City of Albuquerque  
Stormwater Construction Site  
Inspection Report

Project Name and Location	Murphy Express 1358 Wyoming Blvd NE		
Site Contact Name & Agency	Shawn Cook Kevin Chamberlain JMD Construction	ESC File No. NPDES ID No.	520E037
Date of Inspection	1-22-19	Start/End Time	9:35/10:00
COA Inspector Name	Curtis Cherne, Stormwater Quality		
Describe Present Phase of Construction	1st installing utilities		
Type of Inspection:	<input type="checkbox"/> Regular <input checked="" type="checkbox"/> During storm event <input type="checkbox"/> Post-storm event (> 0.25 inch) <input type="checkbox"/> 311 / Complaint Response <input checked="" type="checkbox"/> Follow-Up		
Weather Information			
Weather at time of this inspection?		Temperature: ~30 F°	
<input type="checkbox"/> Clear <input type="checkbox"/> Cloudy <input type="checkbox"/> Rain <input type="checkbox"/> Sleet <input type="checkbox"/> Fog <input checked="" type="checkbox"/> Snowing <input type="checkbox"/> Windy

SHEET NO. **C-4.1**
 JOHN H. NOURDAD
 NEW MEXICO
 PROFESSIONAL ENGINEER
 11/15/17

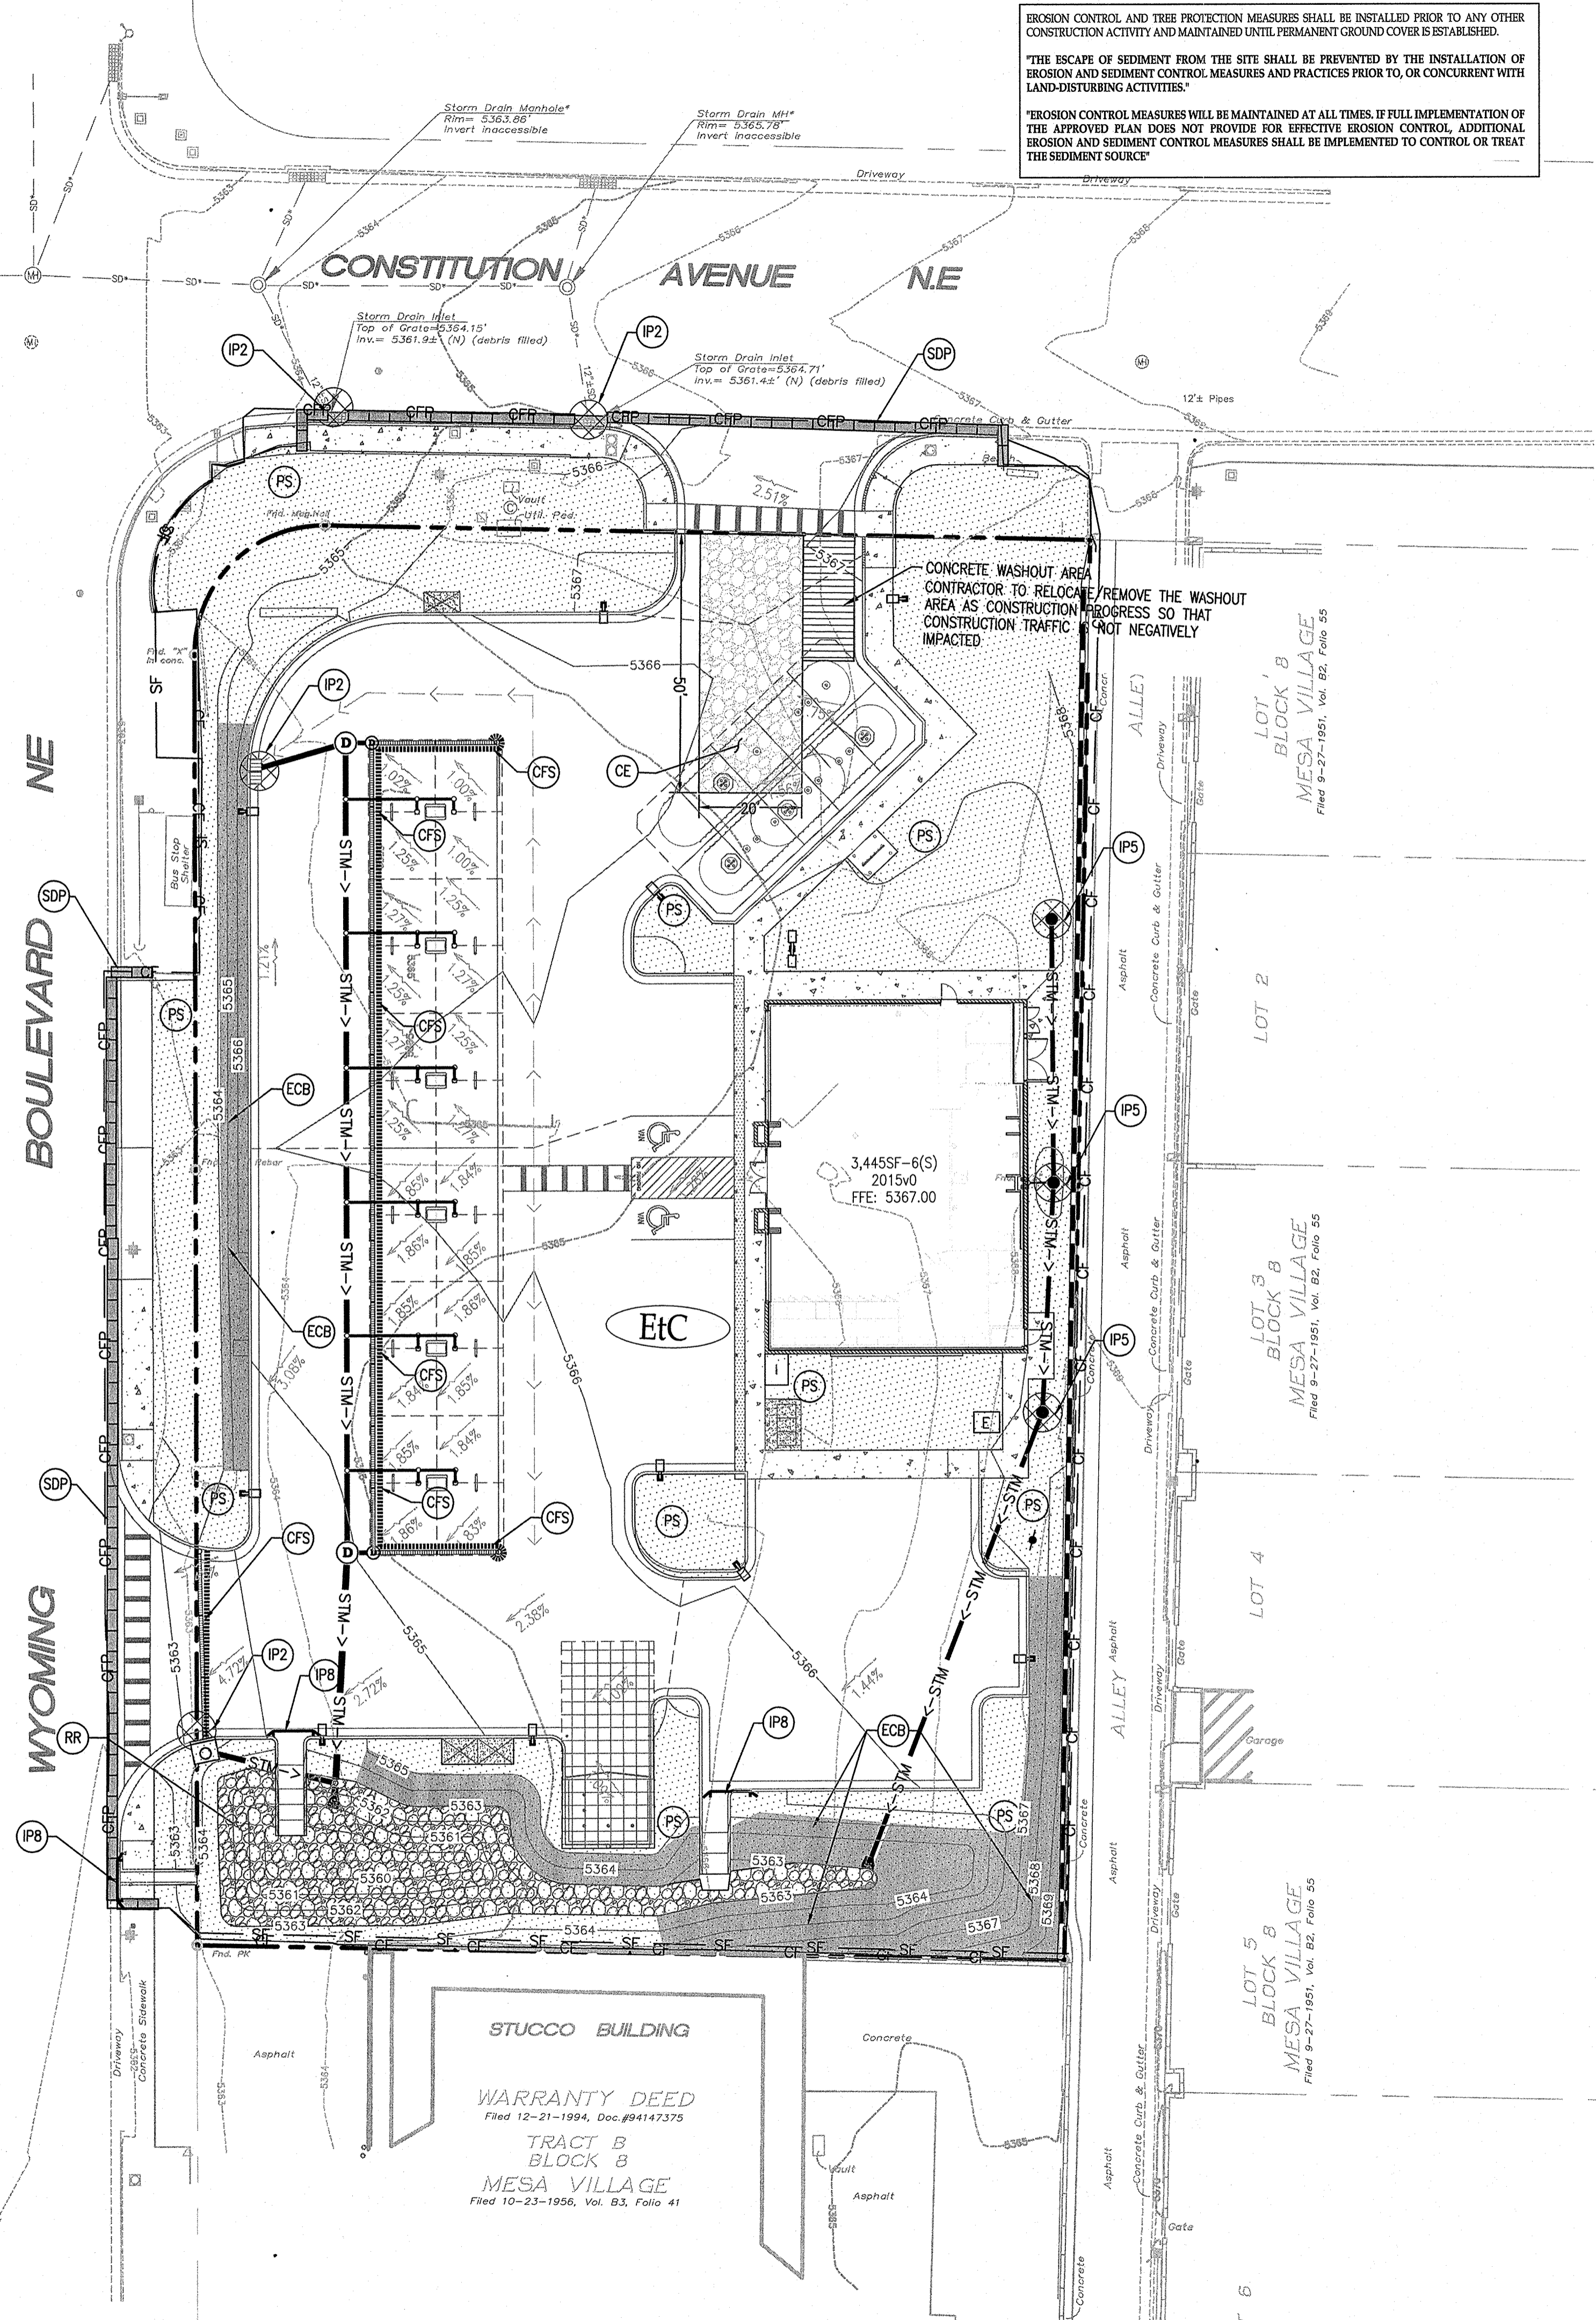
CGP <sup>1</sup> Section	BMP / Activity	Maintenance or Corrective Action Required	Location and Notes
1.5	Post a Notice		
2.2.1	Provide and maintain Natural buffer when Waters of the US < 50 ft		
2.2.3	Sediment control along any perimeter	✓	replace mulch sock west side
2.2.3	Sediment control along any perimeter		
2.2.3	Sediment control along any perimeter		
2.2.3	Sediment control along any perimeter		
2.2.3	Sediment control along any perimeter		
2.2.3	Sediment control along any perimeter		
2.2.3	Sediment control along any perimeter		
2.2.4	Minimize sediment track-out	✓	track-out pad needs to be redone

Maintenance or corrective actions are to be completed within 7 days.
